RE: Response to review comments for Hu Yu Residence Addition, Permit Application Number 2201-224

Below is my response to the comments received following the City's review of the drawings for the above referenced application. Responses are numbered according to the review comments.

Page 1 (A1.01 Site Plan, Notes)

Page 2 (A1.02 Floor Plan, Roof Plan, Building Sections)

SHEET NUMBER:
A1.02

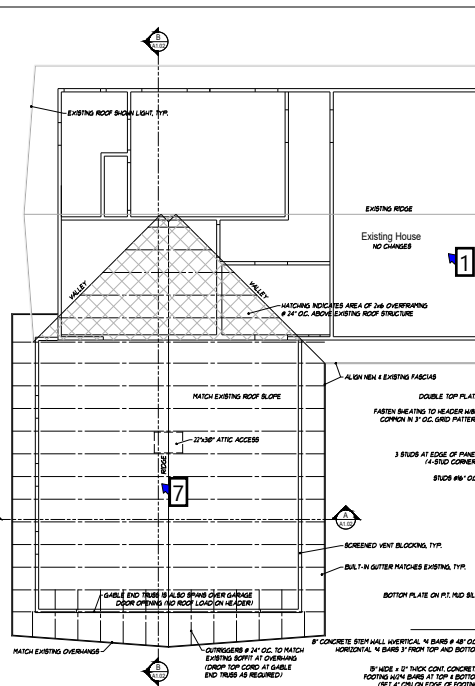
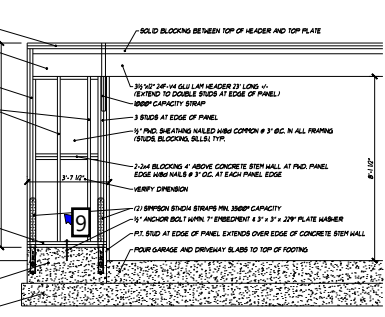
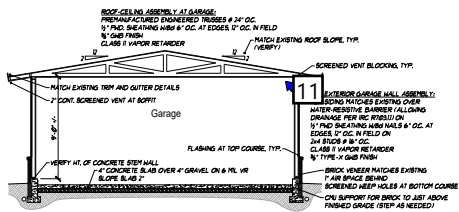
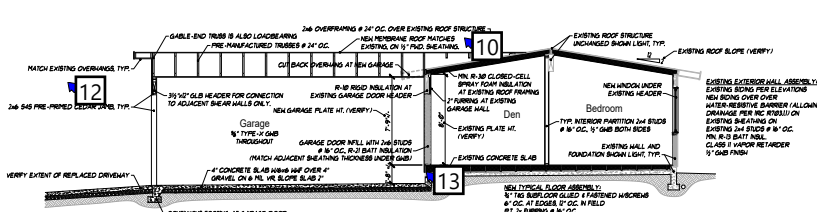
1. The foundation plan is shown on the floor plan, with the perimeter foundation labeled and referenced to the structural engineering drawings. It is noted to be a minimum of 18" below finished grade. There are no changes to the existing building foundation, and the new footings will be doweled to it as per the engineering.
2. The Den is now shown with an egress window.

3. The Den now has a smoke and carbon monoxide detector.
4. The note is added referencing openings and penetrations between the garage and house.
5. The note is added referencing the code section. The plans had originally noted 5/8" type-X gypsum wallboard throughout the garage. The door into the house is noted as 1 3/8" thick, solid core, and self-closing.

6. The new living area will be heated by the existing forced-air furnace, located in the existing house. New ductwork will be connected to the existing ductwork in the existing crawlspace. Floor registers are shown in the bedroom, den, and bathroom. Hot water will also be provided from an existing water heater in the existing house, through new piping in the existing crawlspace.

7. The attic ventilation is shown in the notes under the roof plan.
8. A heat detector is added to the garage (shown and noted as an "H").
9. Shearwalls are now noted on the plans and are described in the new structural engineering drawings.

10. The overframing detail is referenced to the new structural engineering drawings.
11. The truss top plate connection is referenced to the new structural engineering drawings.

12. The structural calculations and drawings show the lateral and gravity design and related connection details.
13. The floor framing connection to the existing foundation is shown in the new structural drawings.

South Elevation

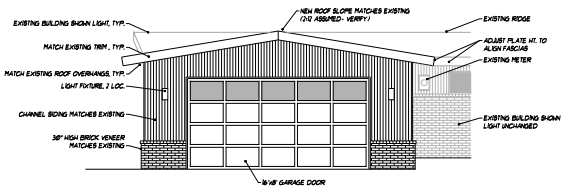
1. The ABE calculation is summarized under the South Elevation drawing. The one-story house is over eighteen feet below the maximum allowable building height.
2. The finished grades, ABE, and building elevation are noted on the elevation drawings.
